Application Reference: 2025/0796

Site Address: 7 Wood Cottages, Sheffield Road, Spring Vale, Sheffield, S36 8ZR

Introduction: This application seeks full planning permission for the erection of side first floor extension over the existing and previous ground floor extension.

All dimensions to be checked on site and any discrepancies to be notified prior to the commencement of work.

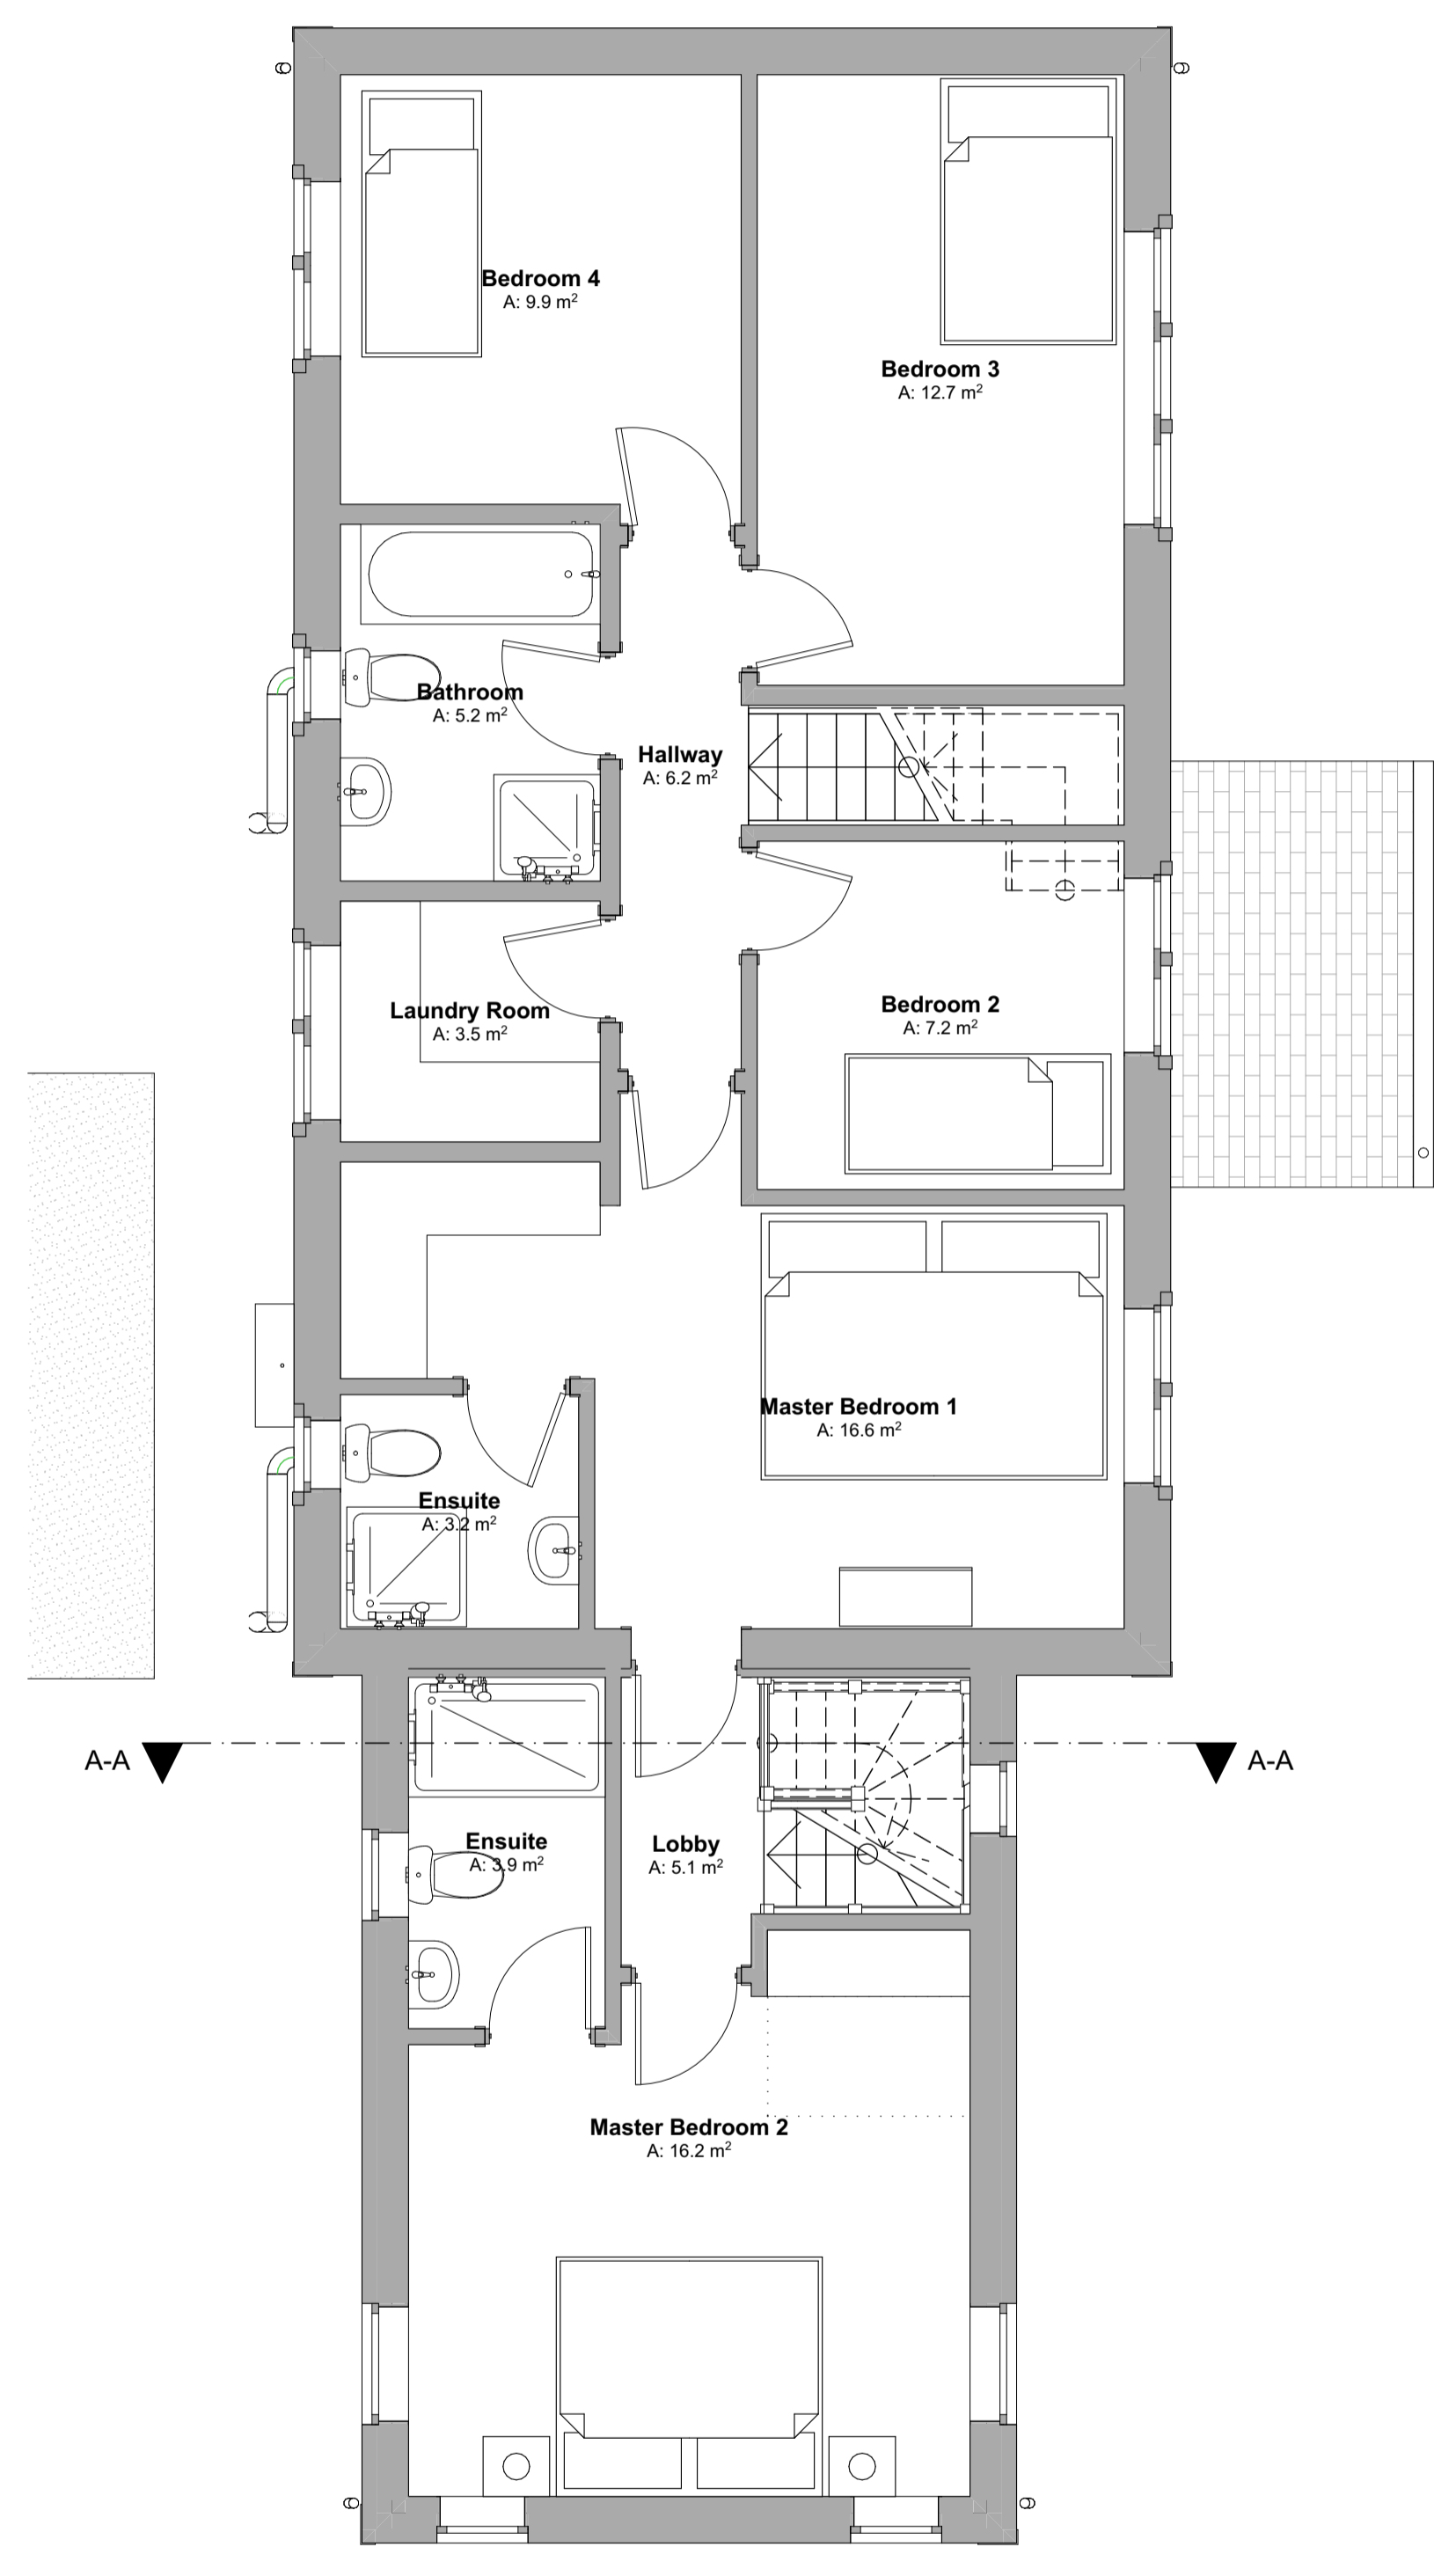
As the proposal is for a first-floor extension above an existing ground floor extension, the footprint of the dwelling would not be increased but there would be an increase in internal floorspace of approximately 26sqm (32sqm gross), this would mirror the existing ground floor extension.
